Appeal Decision

Appeal Ref: APP/R5510/W/22/3295676

12 Owen Road, Hayes UB4 9LB

EXISTING
SIDE ELEVATION 1:100

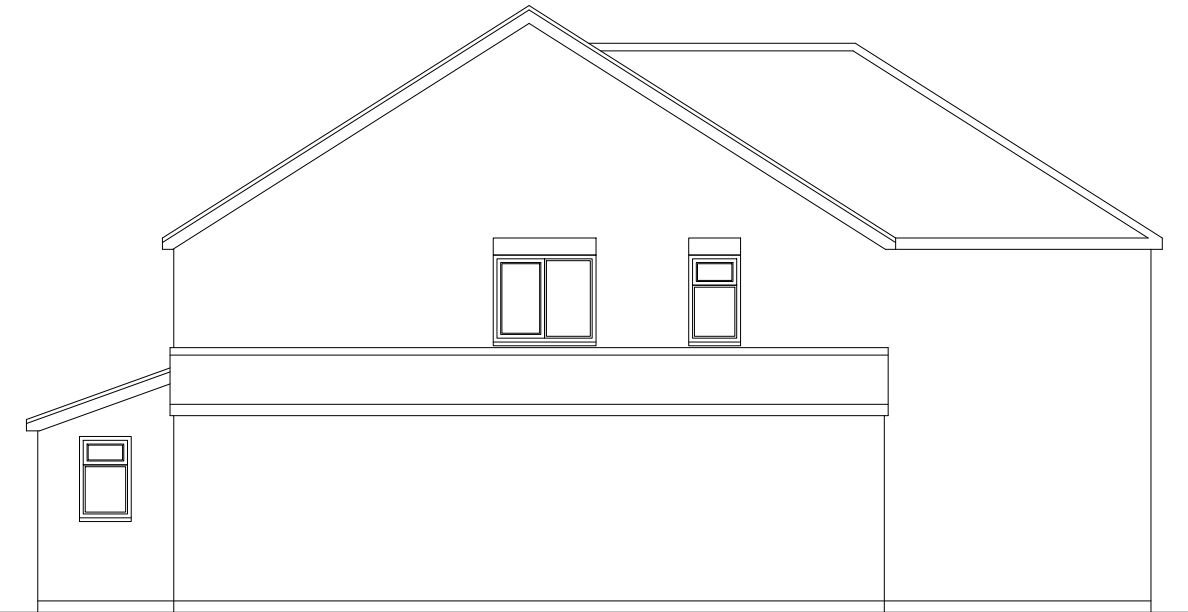
3. The proposal would introduce an expanse of built development within close proximity to the side elevation of 13 Owen Road (No 13) which contains a first floor window. Due to its scale and positioning, the proposal would be a dominating structure that would severely compromise outlook from the first floor side window of No 13 that would be to the detriment of the occupiers living conditions.

PROPOSED
SIDE ELEVATION 1:100

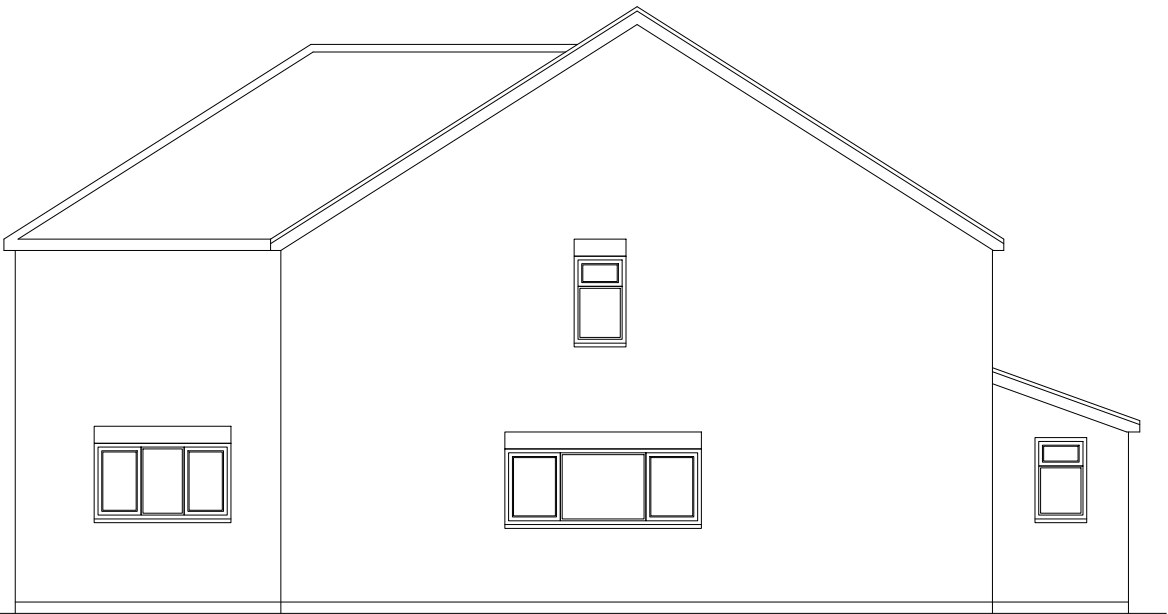
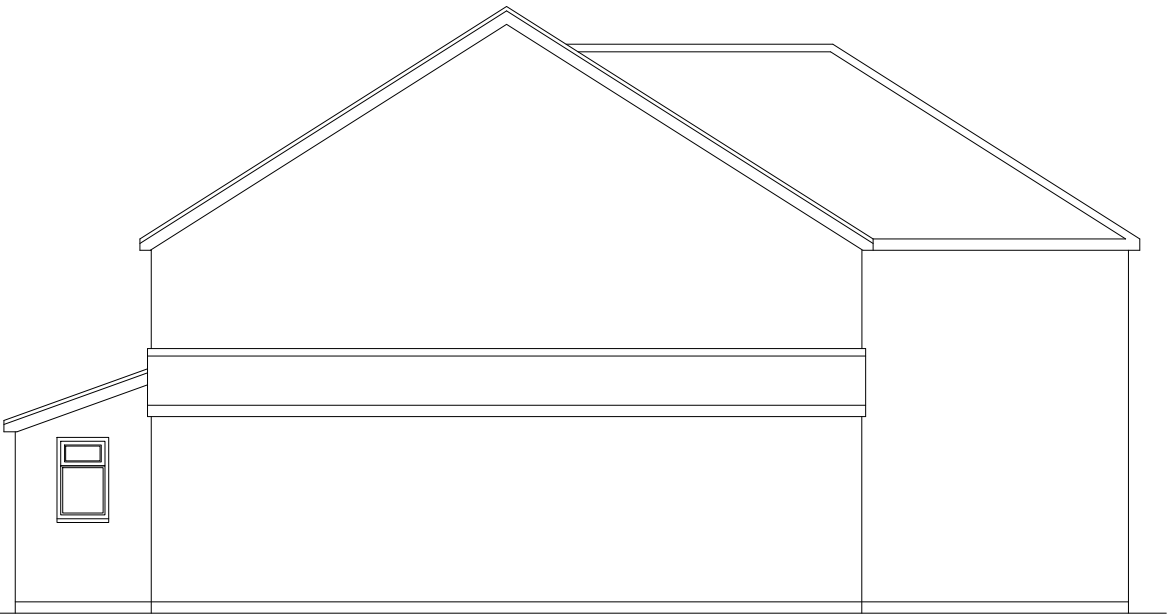
4. A daylight and sunlight assessment has been submitted, including shadow and lighting analysis diagrams. This assessment appears to indicate that the proposal would not overshadow the first floor side window of No 13 however, there is insufficient evidence in terms of how the proposal would effect the amount of natural light into this first floor room of No 13. Given the close proximity of the proposal to the first floor side window of No 13 and the proposals massing, it would have an overbearing effect that would reduce the amount of natural light received into the first floor side window of No 13.

5. Accordingly, the proposal would have a harmful effect on the living conditions of the occupiers of No 13 with regards to outlook and light. The proposal would be contrary to Policies DMHB 11 and DMHD 1 of the Hillingdon Local Plan: Part Two – Development Management Policies which seeks development to protect
